The Planning Inspectorate  
3/18 Eagle Wing  
Temple Quay House  
2, The Square  
Bristol  
BS1 6PN

9<sup>th</sup> June 2015

***A14 Cambridge to Huntingdon Improvement Scheme  
Written submission (ID: 10030592) detailing essential changes to the  
application that we recommend be included as formal conditions  
of any development consent order***

**BUCKDEN ROAD NORTH WORK NO. 9 - WORKS PLANS SHEET NO. 7 (GENERAL ARRANGEMENT SHEET NO. 5 & 6)**

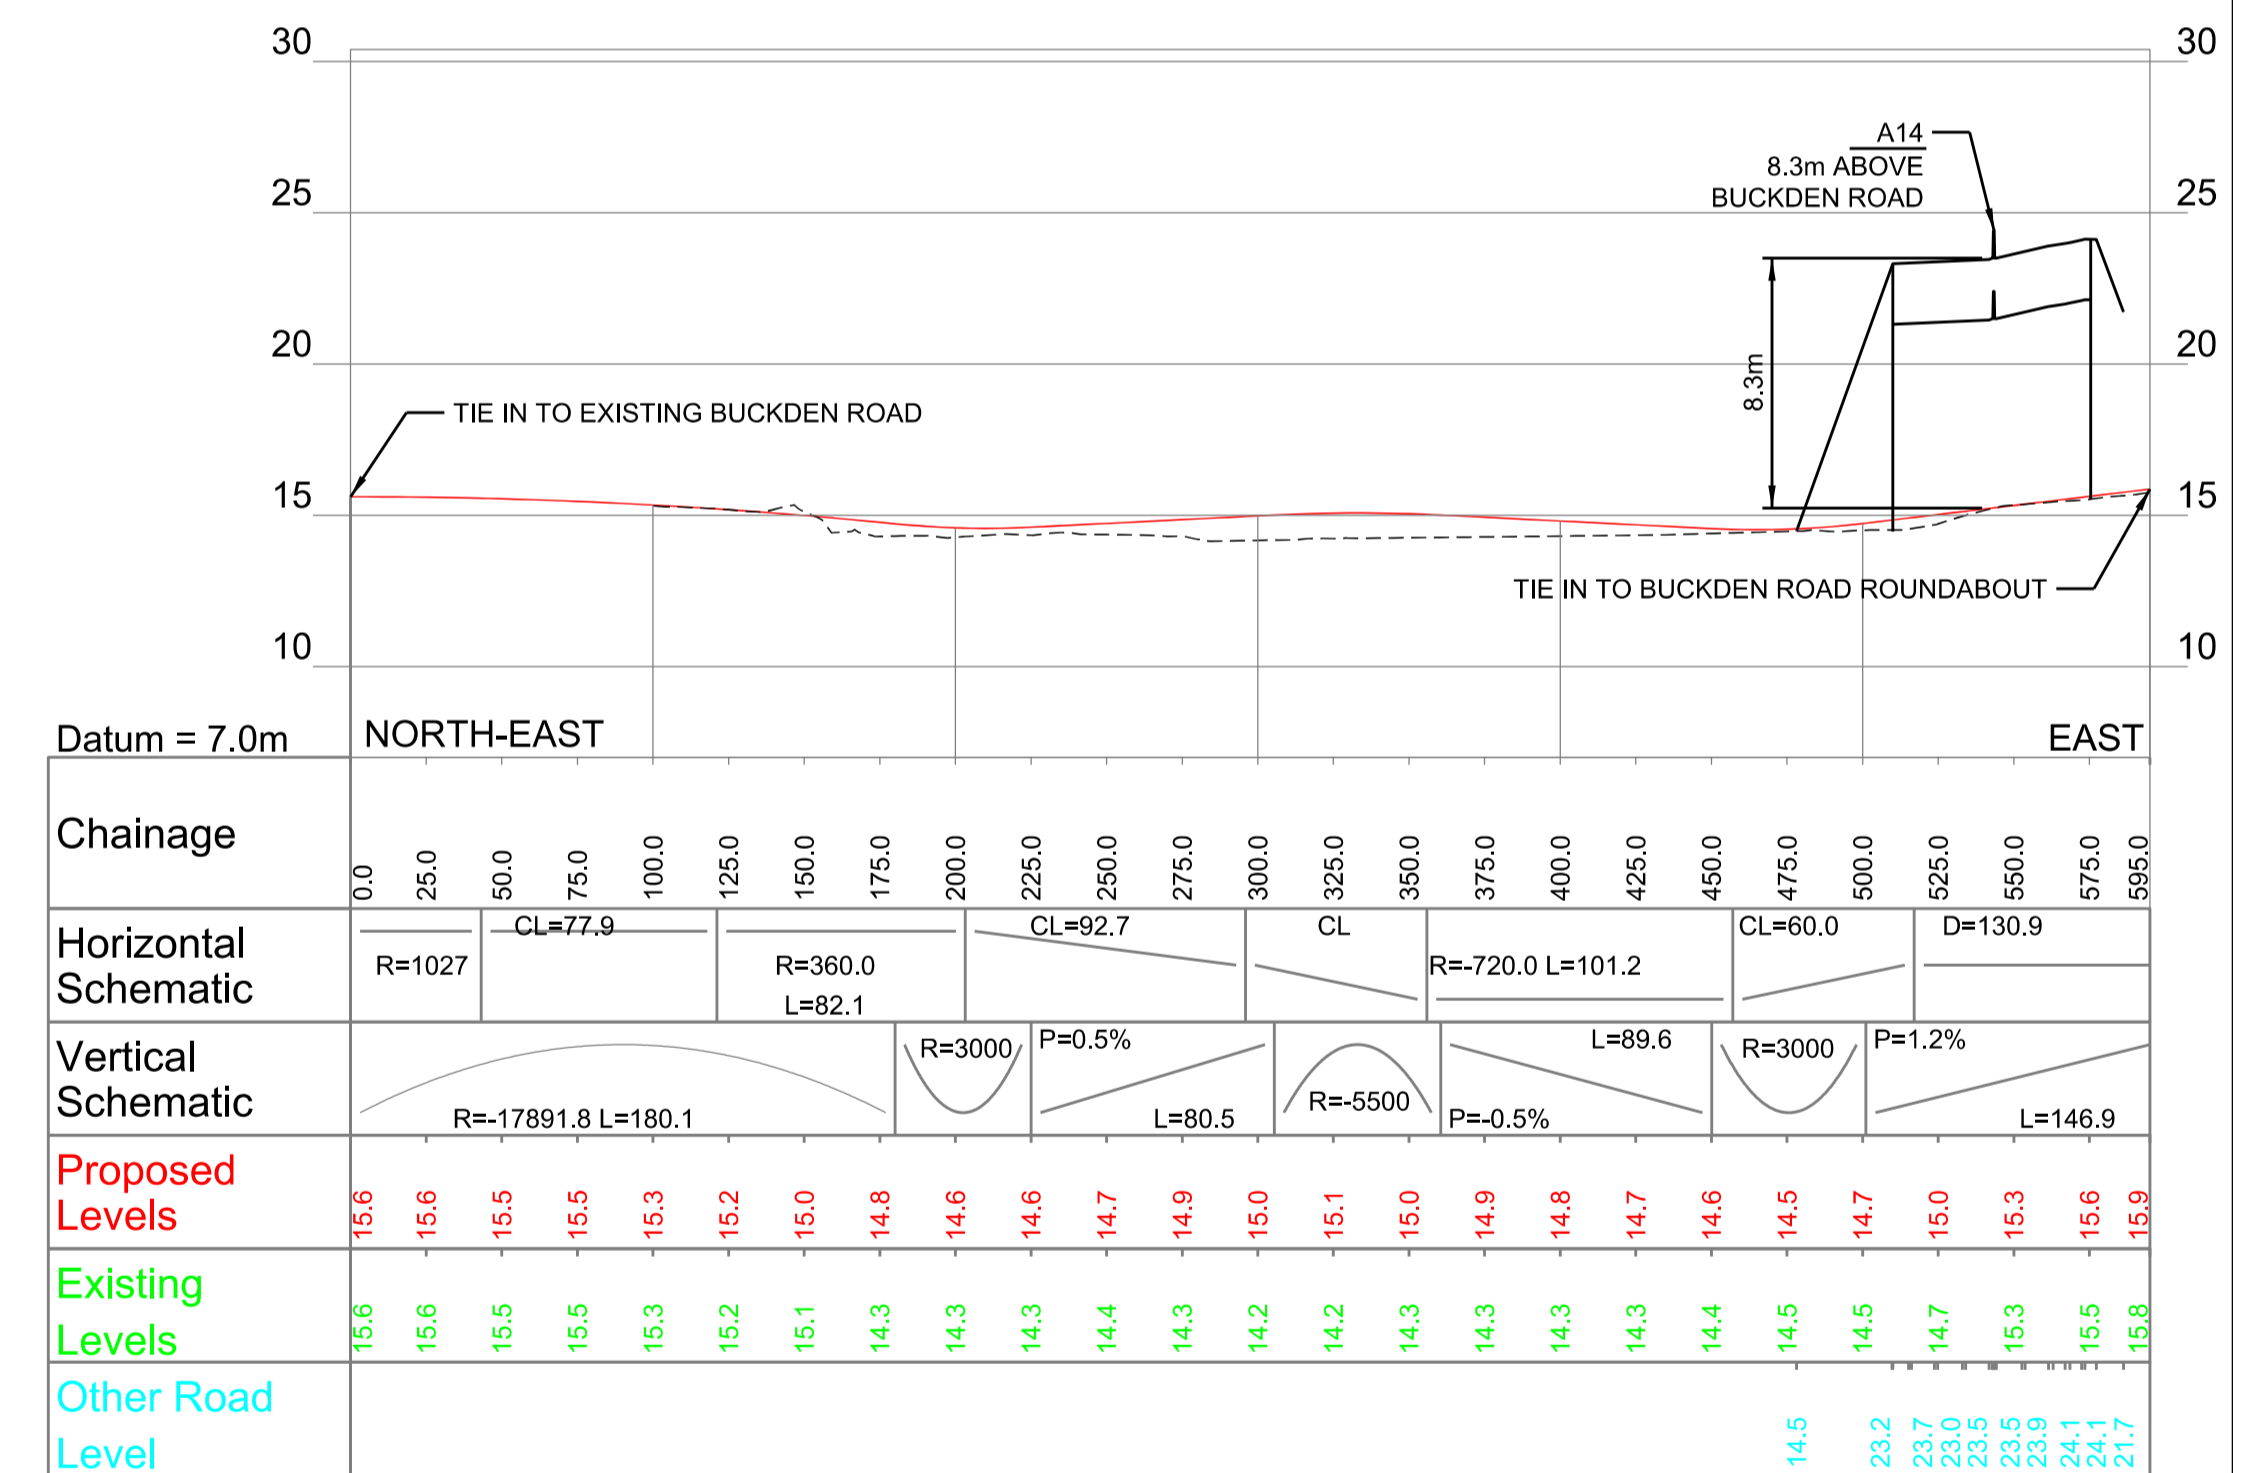
The revised plans show the creation of new cyclepaths alongside the realigned roads north of Buckden (specifically alongside Brampton Road and alongside Buckden Road/B1514). The plans also show a surfaced byway from the A1 access road across to Grafham Road. These are welcome proposals that reflect the existing need for better NMU routes in this location. But the proposals need to be more detailed and/or expanded to create a fully connected set of NMU routes. The following details should be added or confirmed:

- The new NMU paths alongside Brampton Road and alongside Buckden Road/B1514 should be at least 2.5m wide.
- The plans state that the “Byway will be improved as required to be fit for use by vehicles”. It is not clear what is intended for this Byway. The proposed resurfacing of the Byway is a desirable upgrade that should be designed to provide a long term surface for use by all NMUs. If the surface is designed for use by motor vehicles, this should only be for a short term use to support the construction of the new A14 and when the construction is complete the Byway should be restricted to NMU use only.

- The plans should be extended to include an NMU connection to Buckden village. There is an existing path on the east side of the A1 and this should be upgraded to a minimum width of 2.5m to provide a higher quality connection between the new NMU path alongside Brampton Road and Buckden village.
